Our ref: NO/2019/112169/02-L01
Your ref: 3/2019/0930
Date: 27 December 2019

**PROPOSED EXTENSION TO FACTORY AND CREATION OF NEW CAR PARK WITH ACCESS.
CLITHEROE LIGHT ENGINEERING, UNITS A-C, UPBROOKS INDUSTRIAL ESTATE, CLITHEROE. BB7 1PL.**

PROPOSED SITE PLAN

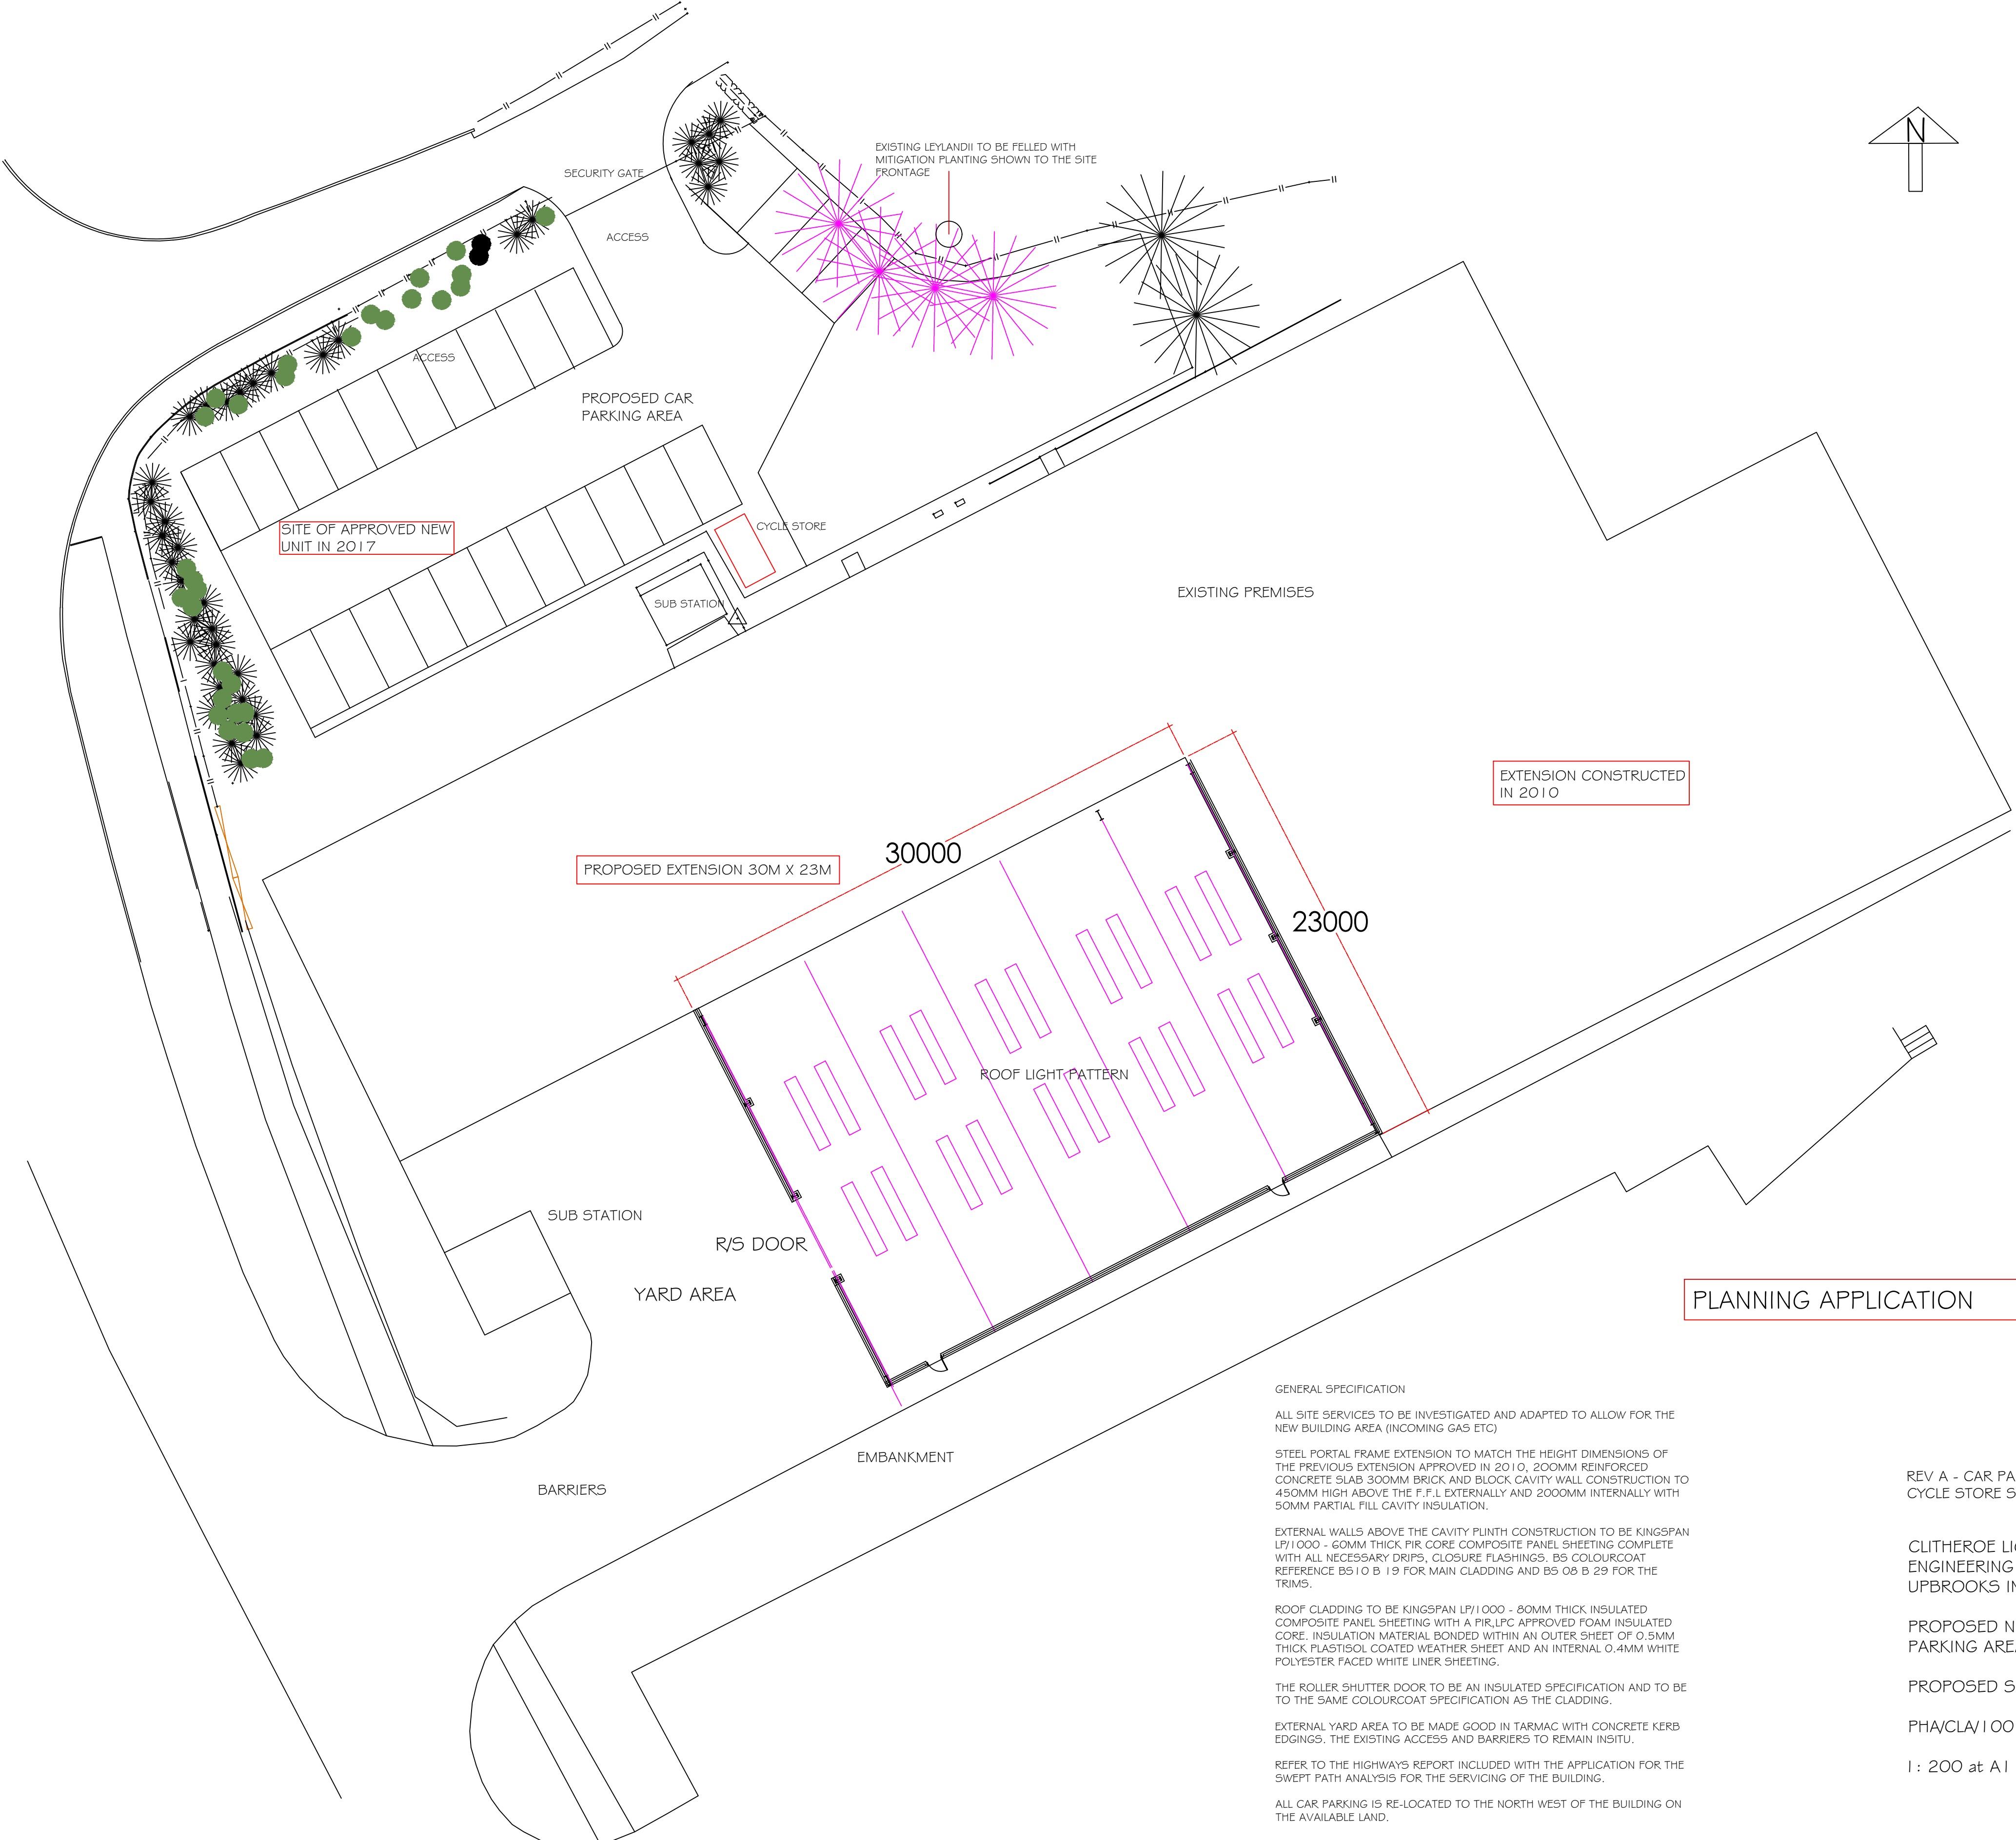
The submitted FRA and topographic survey do not adequately demonstrate that the floodplain will not be infilled by the proposed car park.

To overcome our objection, please provide the following:
A topographic survey drawing that shows the levels with the site as it is currently.
A topographic survey model which clearly shows the full details of the proposed car park, including levels to demonstrate that there will be no infilling as stated in the FRA.
